December 2, 2016

SUBJECT: **Modification Request of Section 404 Regional General Permit No. 31 and Section 401 General Water Quality Certification No. 3886** for the proposed Interstate 85 (I-85) Widening and Interchange Improvements from north of NC 73 (Davidson Highway / Exit 55) to north of SR 2180 (Lane Street/Exit 63), Cabarrus & Rowan Counties, Divisions 9 and 10. Federal Aid Project No. FANHIMF-085-2(61)55, TIP Project No. I-3802A.

The permit drawings for these three sites have been revised to depict the additional bank stabilization at Site 2, temporary impacts at Site UC-1, and the additional bank stabilization at Site 18. They have been included in this modification request along with the revised impact summary tables.

PROJECT REFERENCE NO. I-3802A	SHEET NO. 6
RW SHEET NO.	
ROADWAY DESIGN ENGINEER	HYDRAULICS ENGINEER
BLYTHE

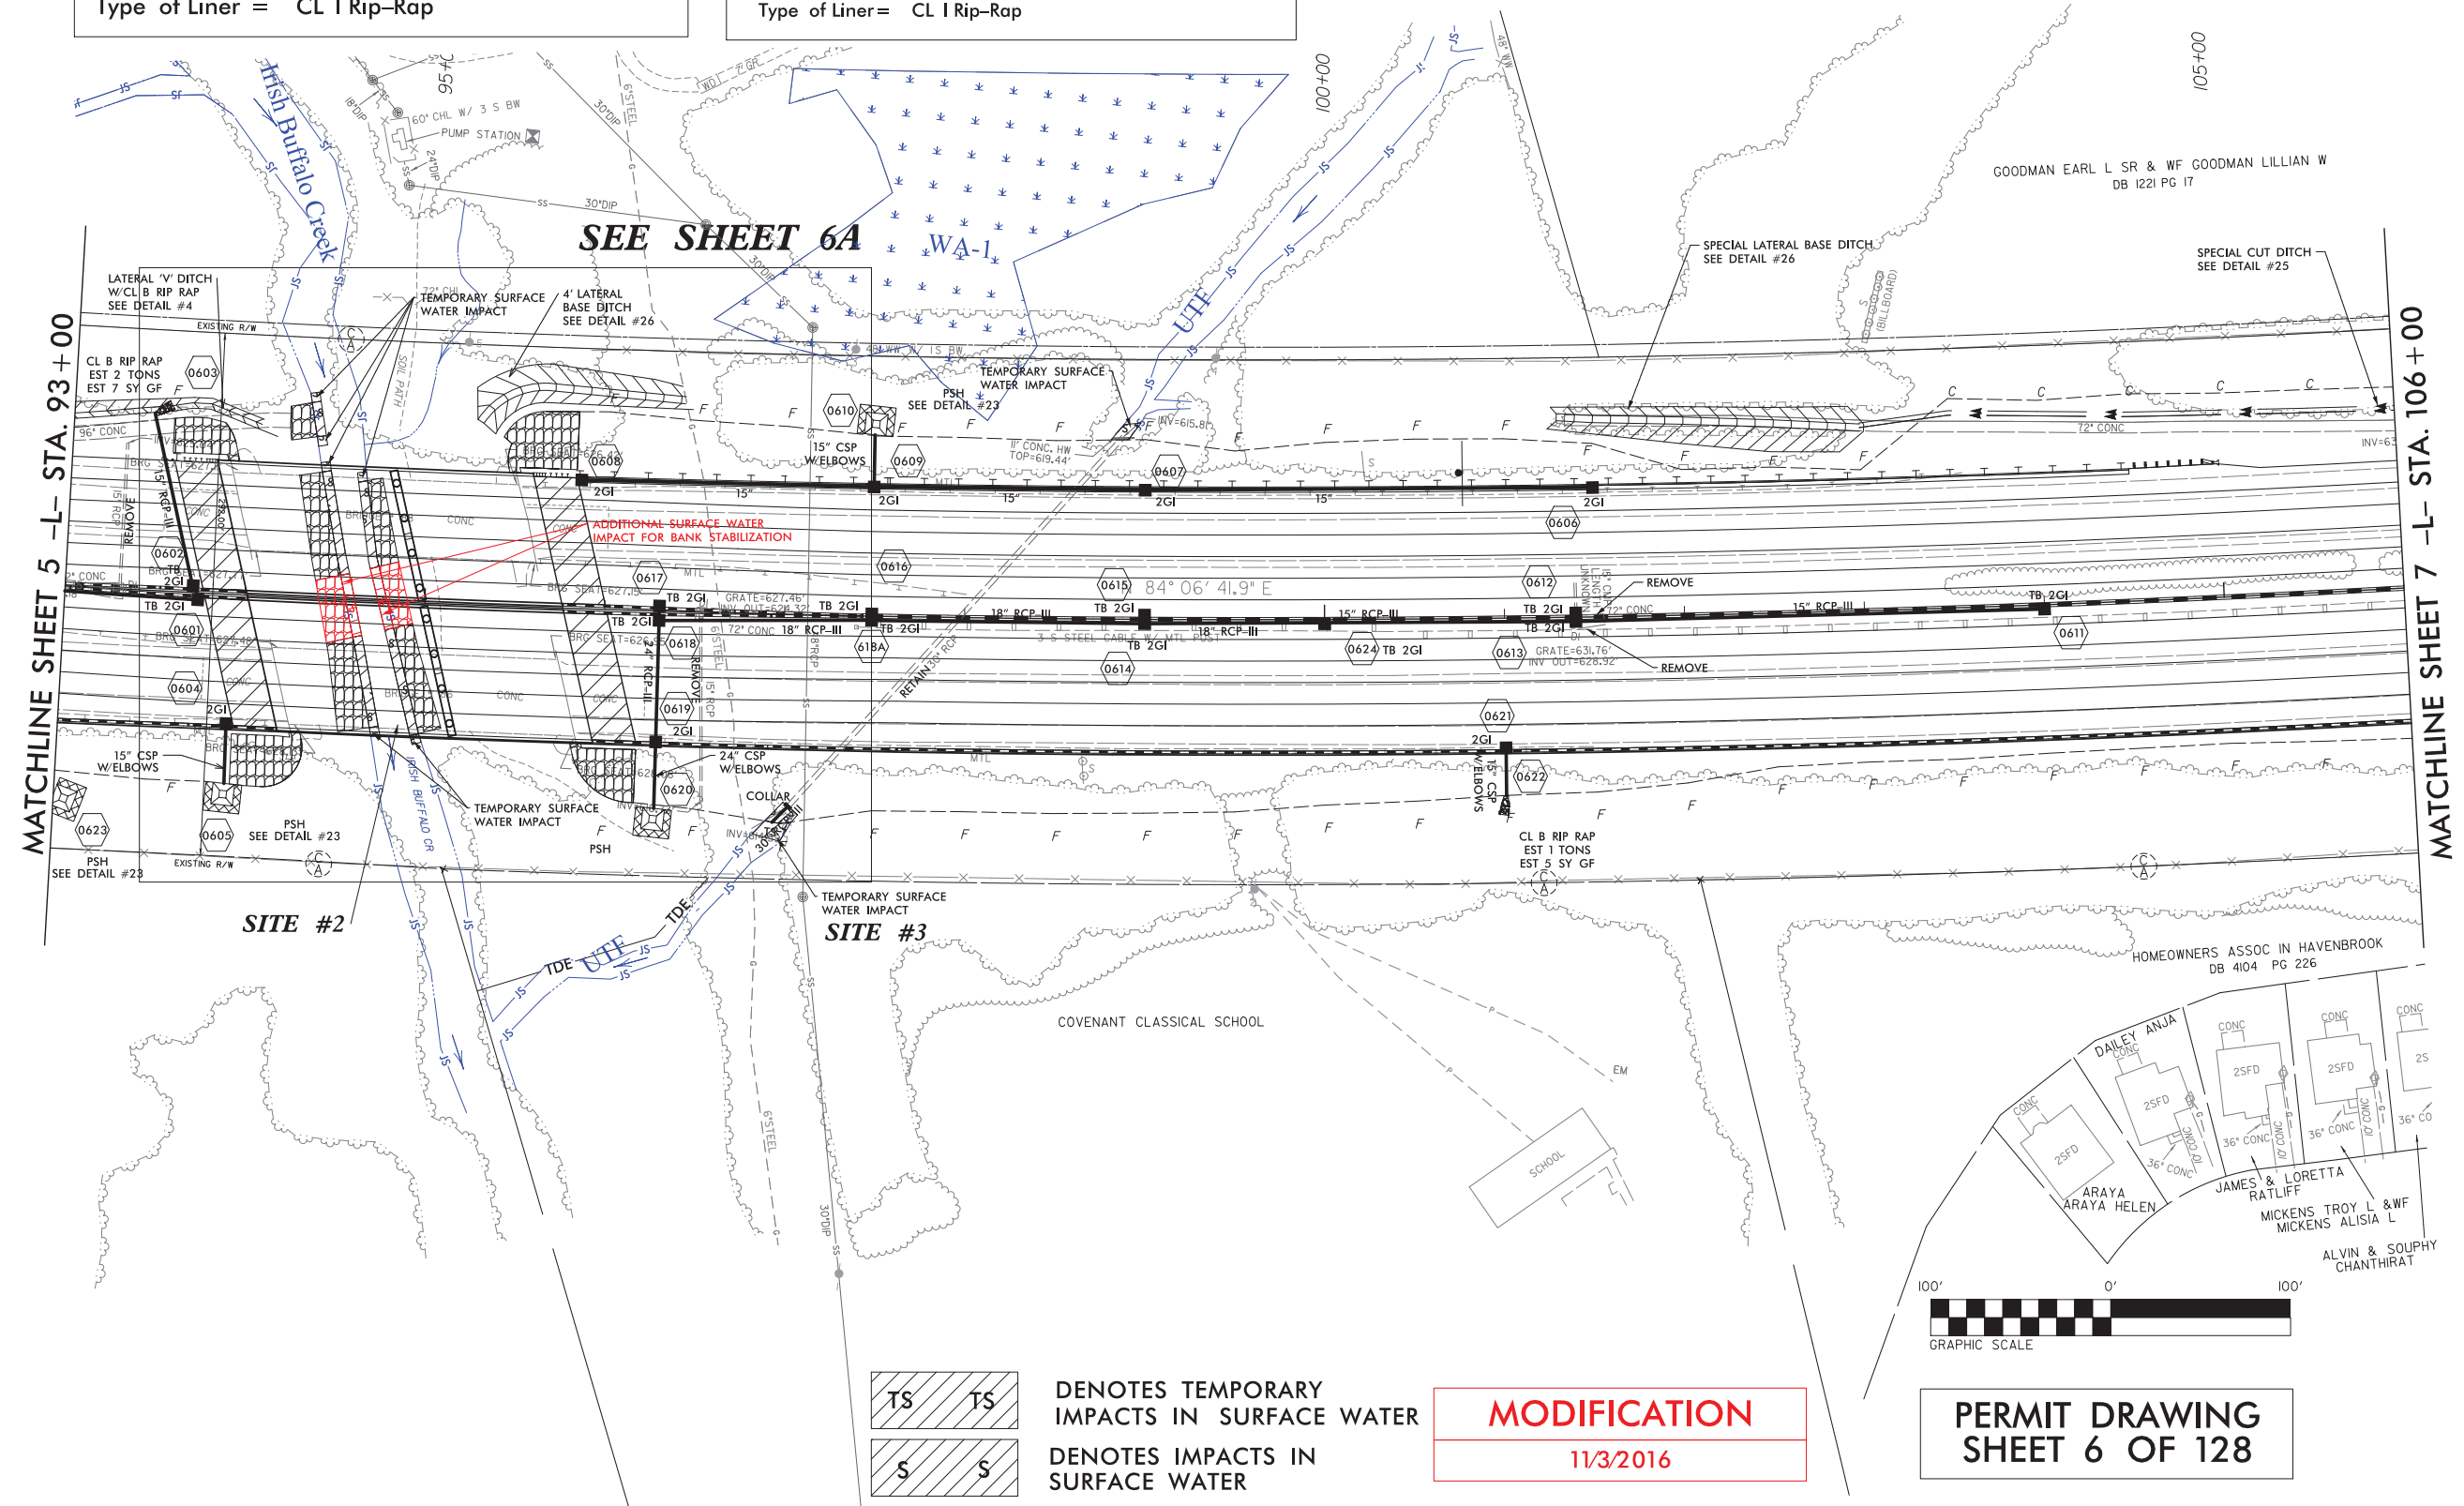
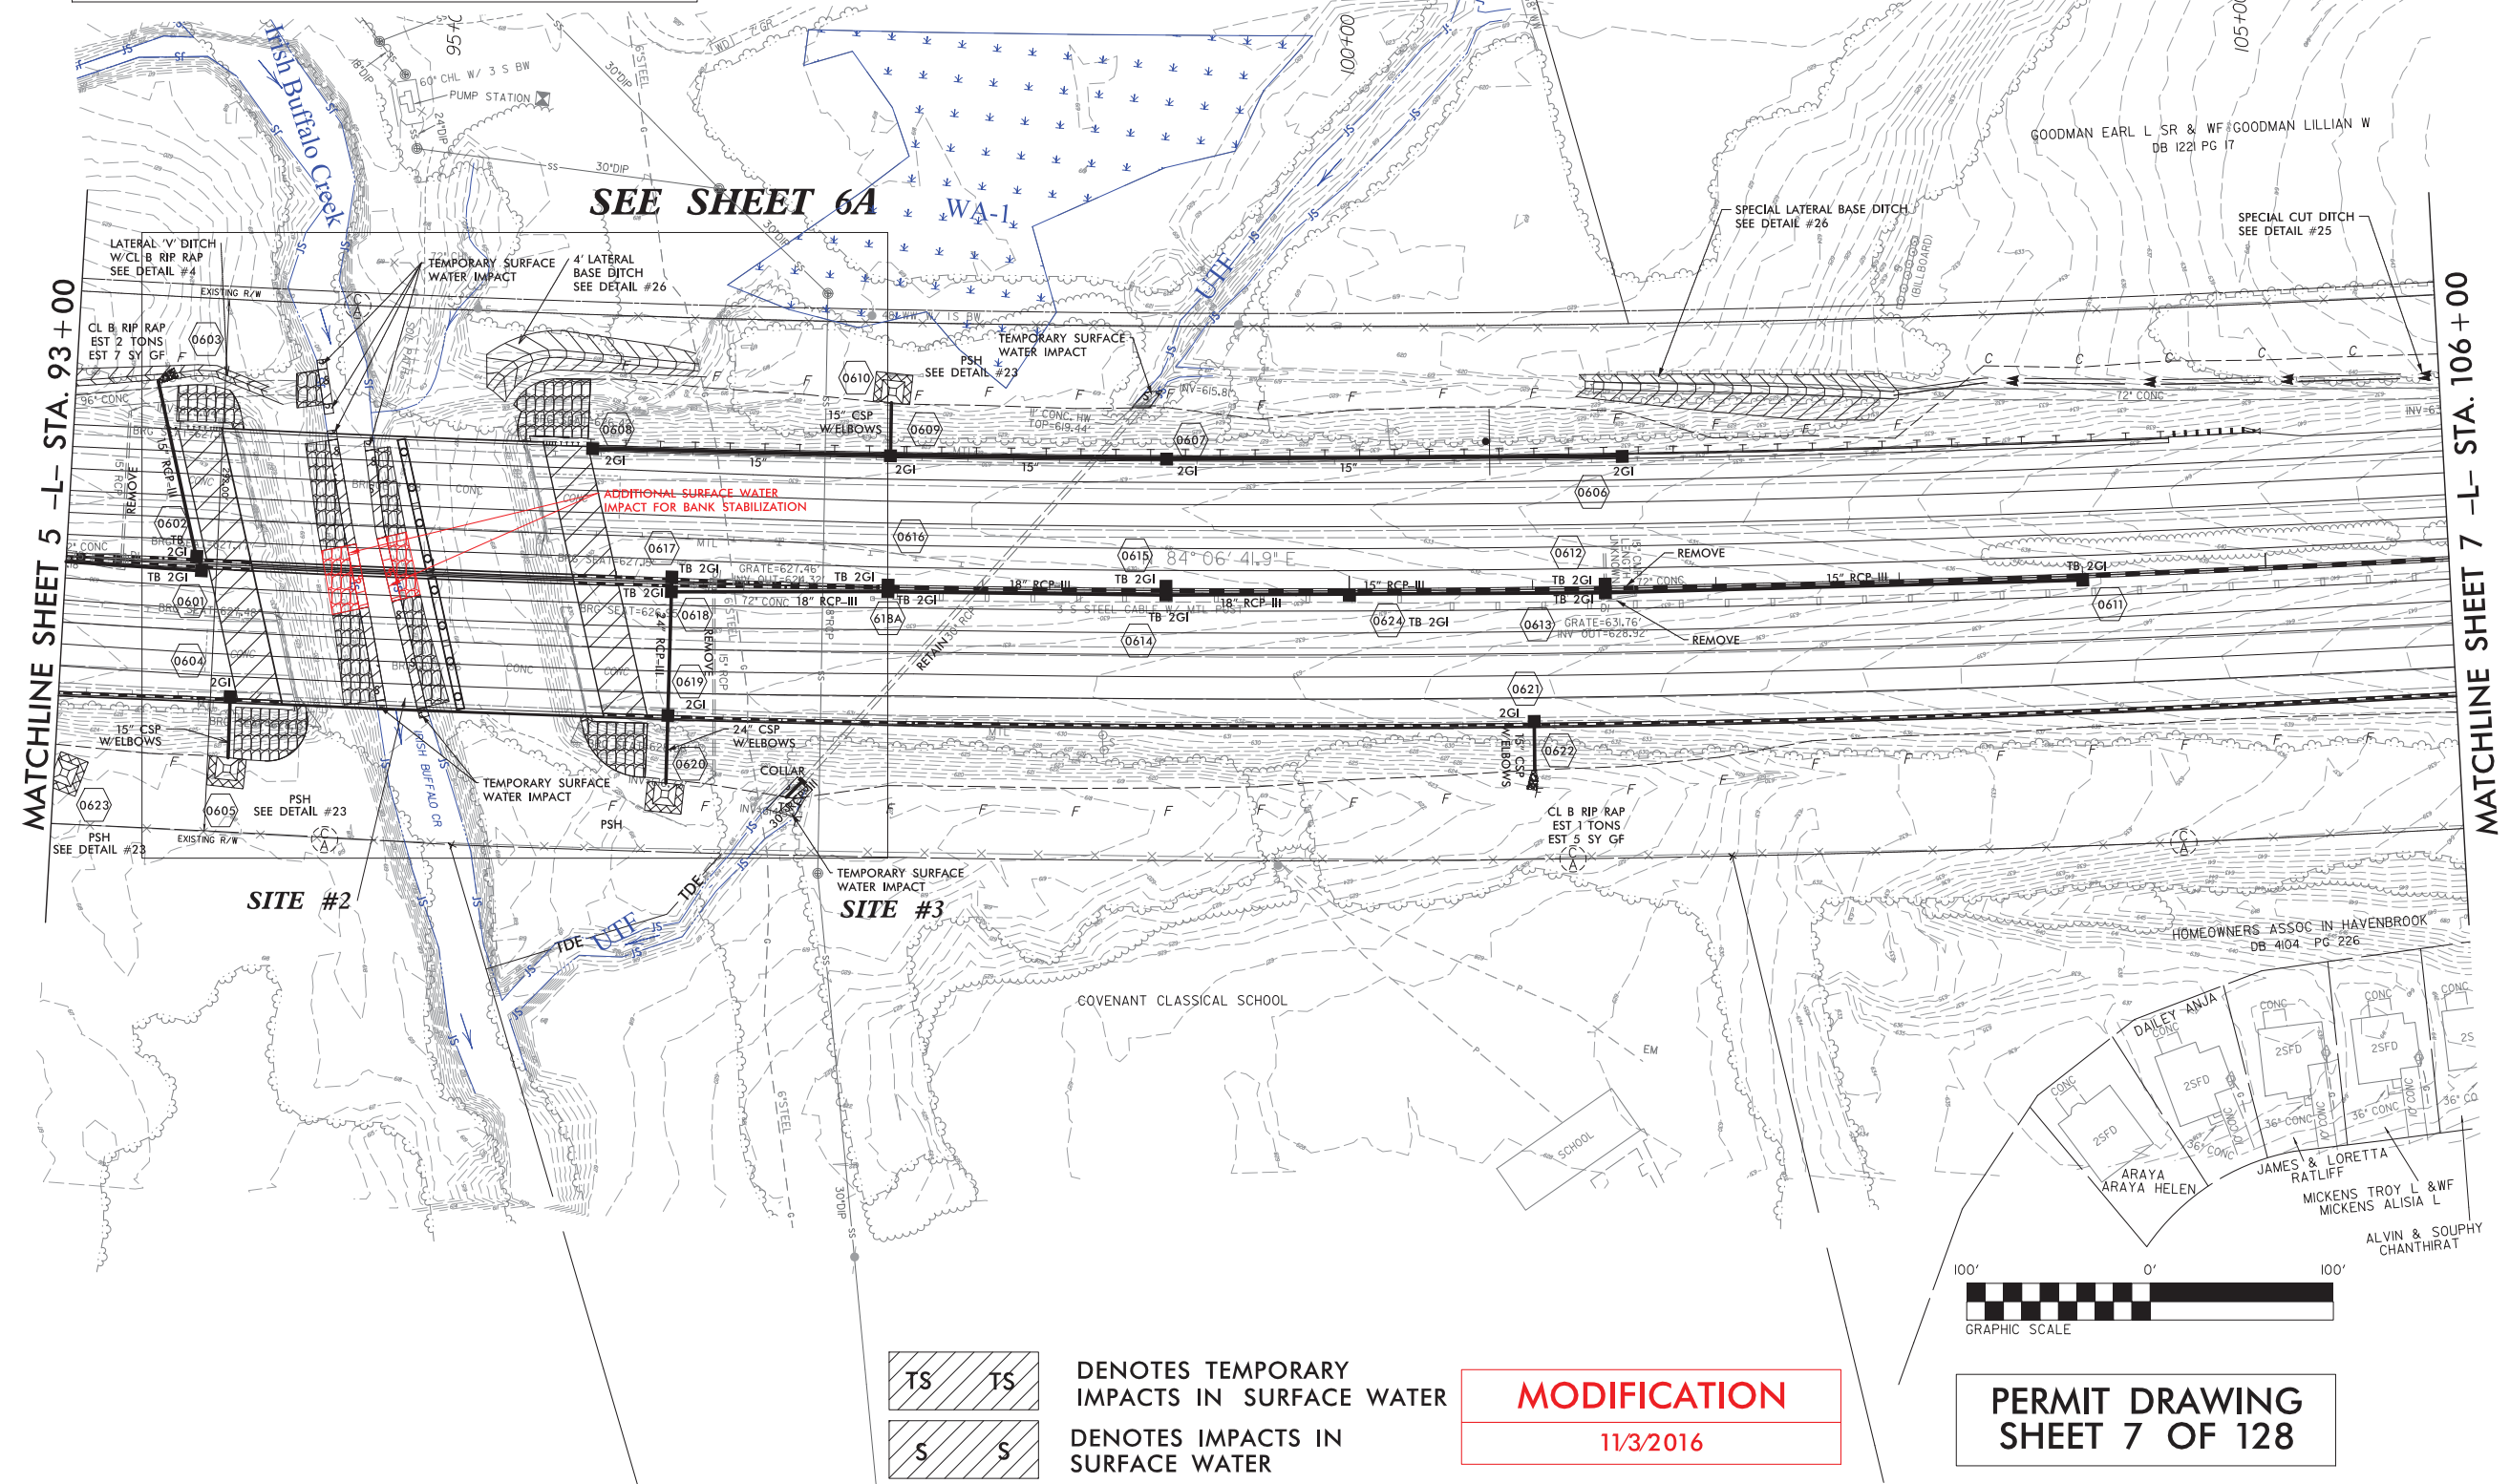
During the same field review for Site 18 on November 17, 2015, Ms. Hood requested that additional riprap be placed on the banks of Irish Buffalo Creek under the existing bridge to prevent erosion from existing shading and potential vegetation die-off. As a result, Class II riprap is being proposed at this location with geotextile fabric to be installed between the Class II riprap and the stream bed and stream banks.

Previous Site 2 impacts included 30 linear feet of temporary stream impacts and 137 linear feet of bank stabilization impacts. The additional bank stabilization at Site 2 will result in an additional 35 linear feet of permanent bank stabilization impact. Consequently, the proposed overall total for Site 2, including the previously-permitted impacts and currently proposed impacts will be 20 linear feet of temporary impacts and 172 linear feet of bank stabilization impacts. As a result of the currently proposed bank stabilization, temporary impacts at Site 2 will decrease from the permitted total of 30 linear feet to 20 linear feet due to the elimination of two 5 linear foot sections of temporary impact. No other changes to permitted wetland and stream impact are proposed for Site 2.
